MECKLENBURG COUNTY  
Park and Recreation Department

MEMORANDUM

**DATE:** January 25, 2024

**RE:** Rezoning Petition #2023-164  
PID# 21912104

DRAWING NO.: **RZ-01**

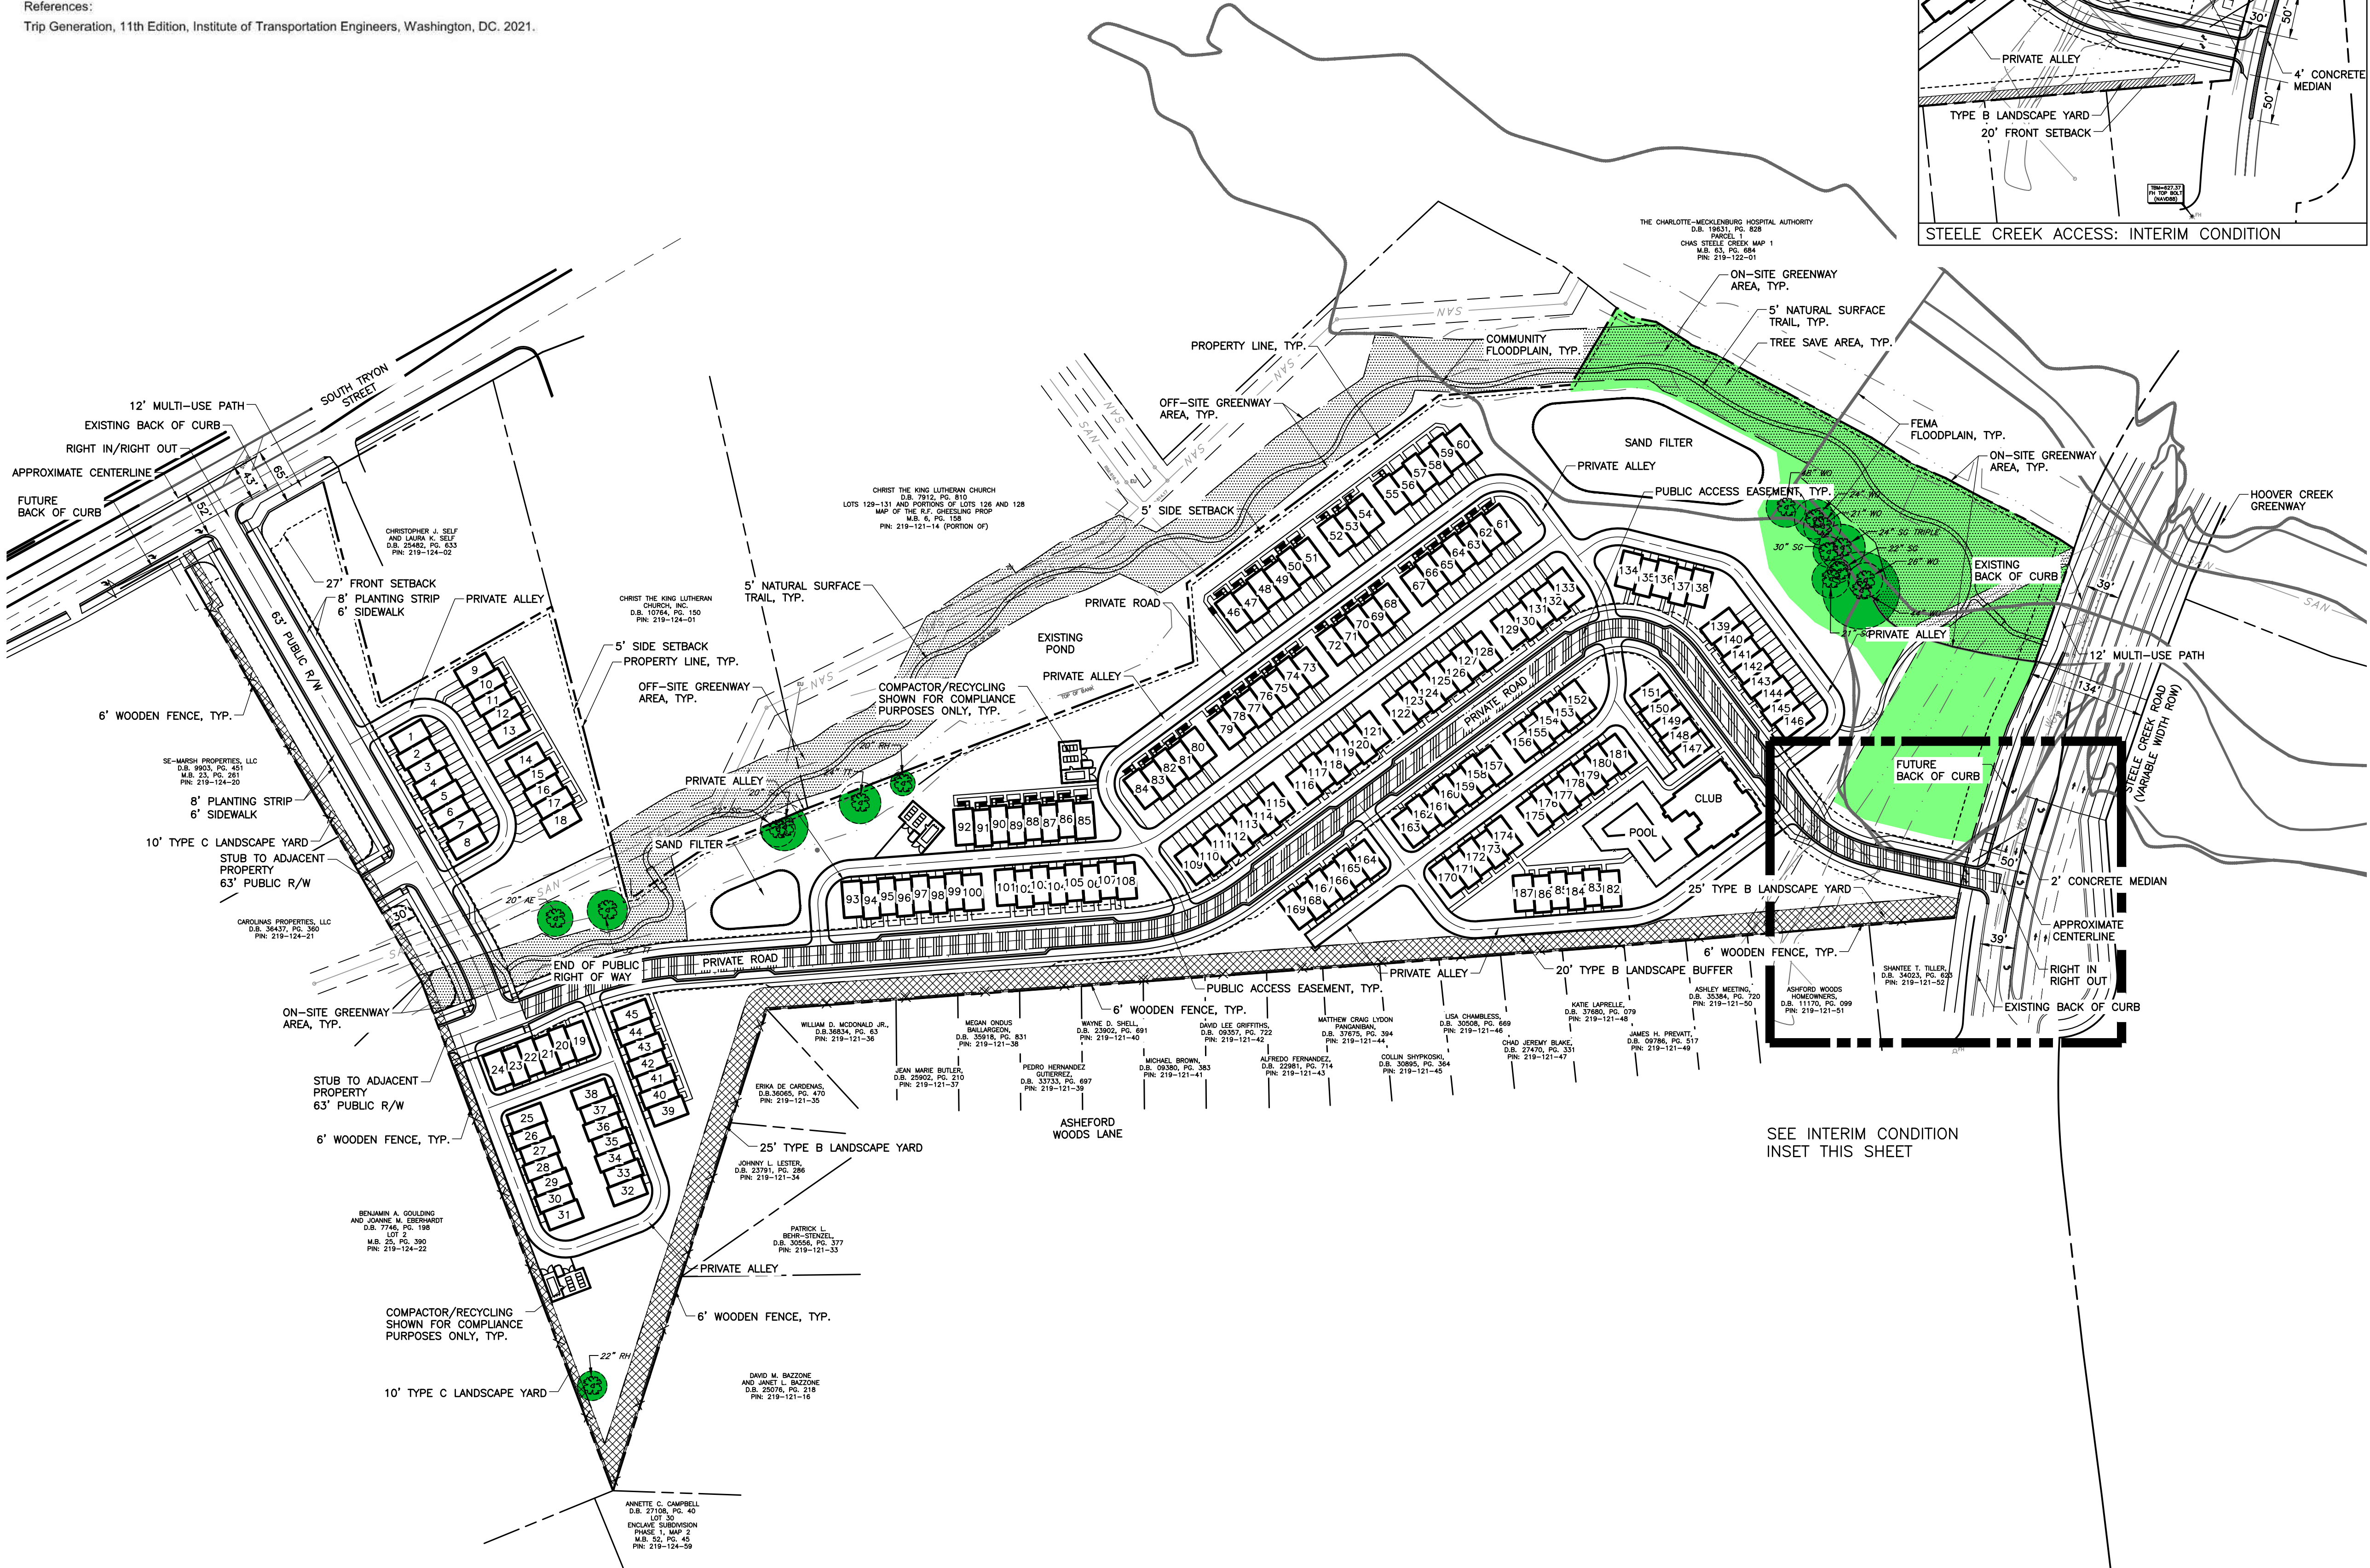
MCPR requests a bicycle and pedestrian connection between Steele Creek Road and Generations Street Park (PID 21912422). The connection can occur through publicly accessible trail development, sidewalks/multi-use paths, or a minimum of 60' wide trail easement to be dedicated and conveyed to Mecklenburg County.
